KITITAS COUNTY

MEMORANDUM

TO: All Staff
FROM: Public Works Plan Review Team
DATE: September 5, 2025
SUBJECT: BL-25-00010 Folden

**RECORD OF SURVEY**  
 A PORTION OF THE SW 1/4 OF SECTION 16,  
 TOWNSHIP 21 NORTH, RANGE 14 EAST, W.M., KITTITAS COUNTY, WASHINGTON

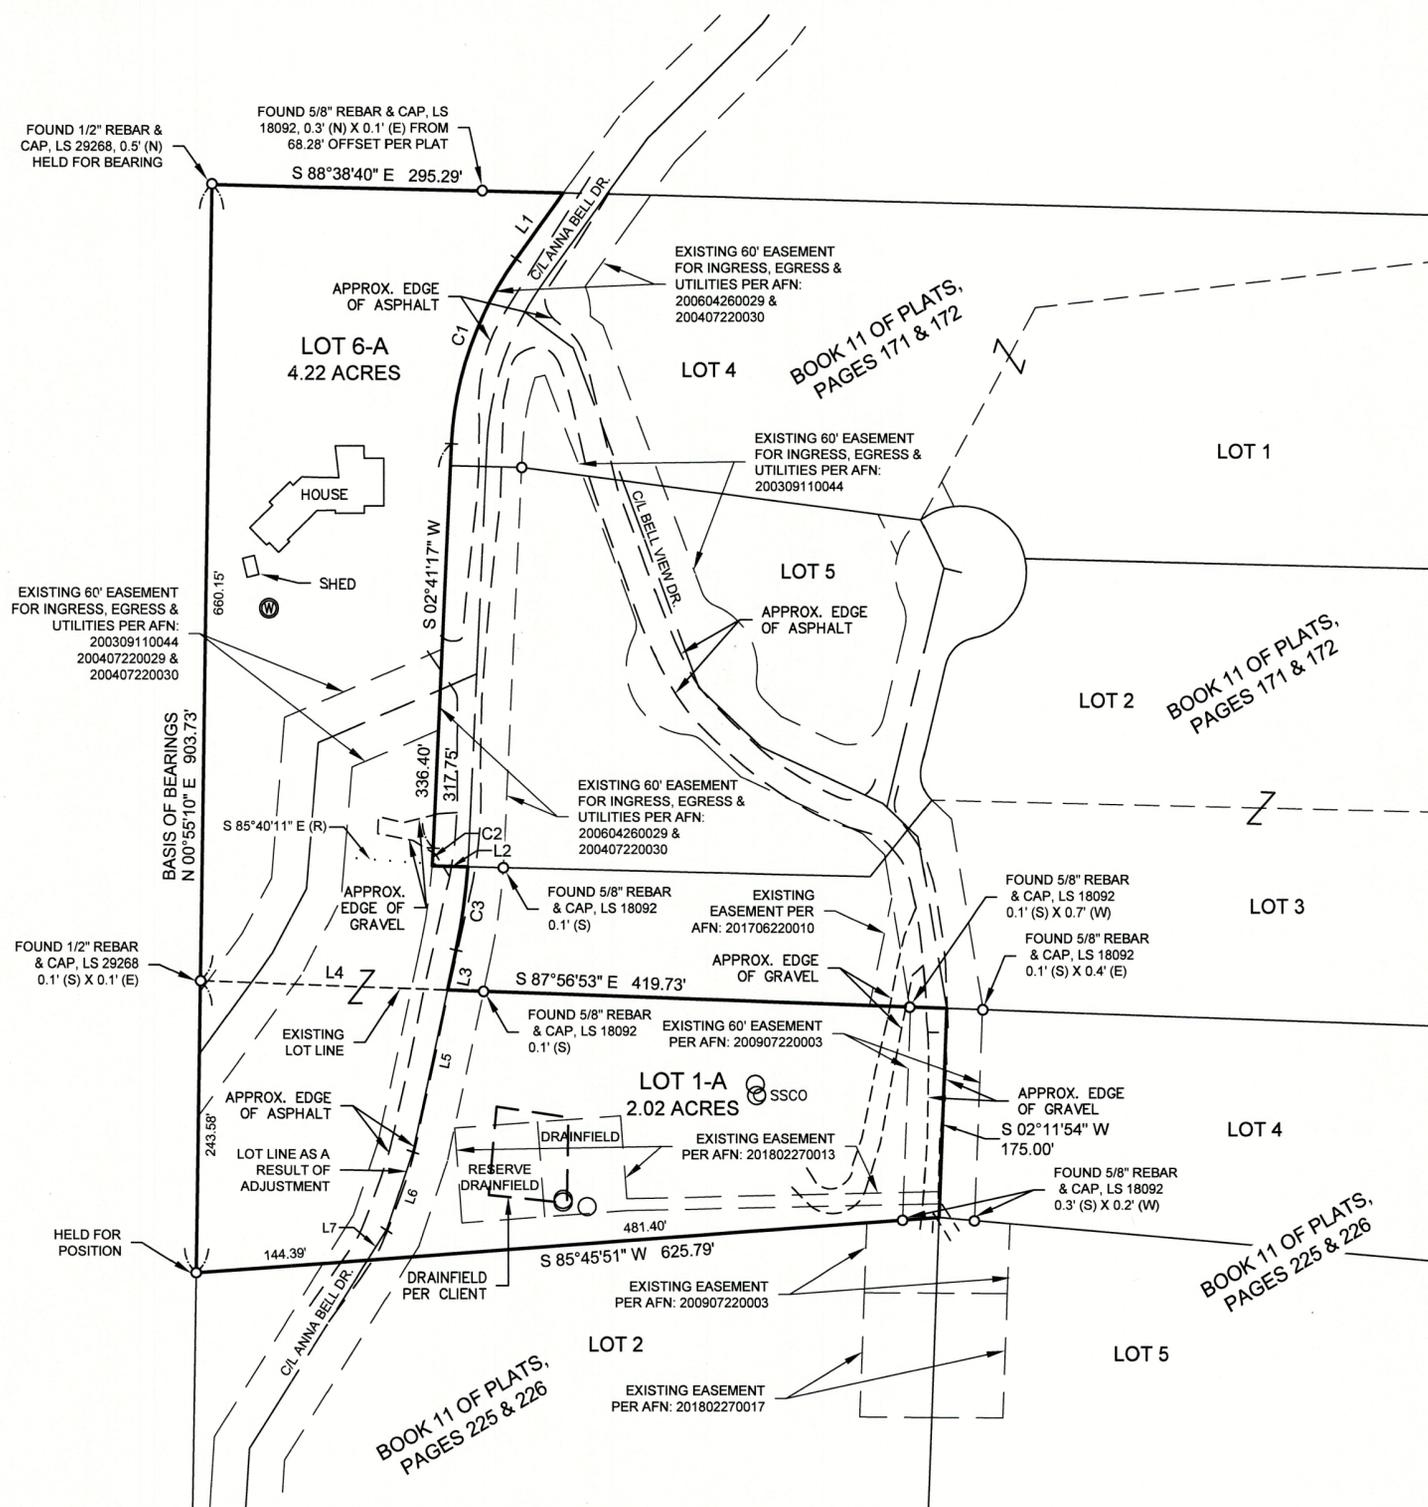
SURVEY	<ol style="list-style-type: none"> 1. As a minimum, the new lot line should have corners set and shown on the face of the map or a note stating why this was not done. <p>Of Note</p> <ol style="list-style-type: none"> 1. There are multiple property corners shown that are not tied into the survey. If any of them were utilized as survey control, they should include bearings and distances to tie their position to the survey. 2. There are multiple corners that include distances from calc position to found position. The majority of these corners cannot be calculated from the data shown on the map, and would require additional documents to calculate. If a corner is shown as not matching the calculated position, it would make sense to include suitable data to calculate the position from the map. (JT)
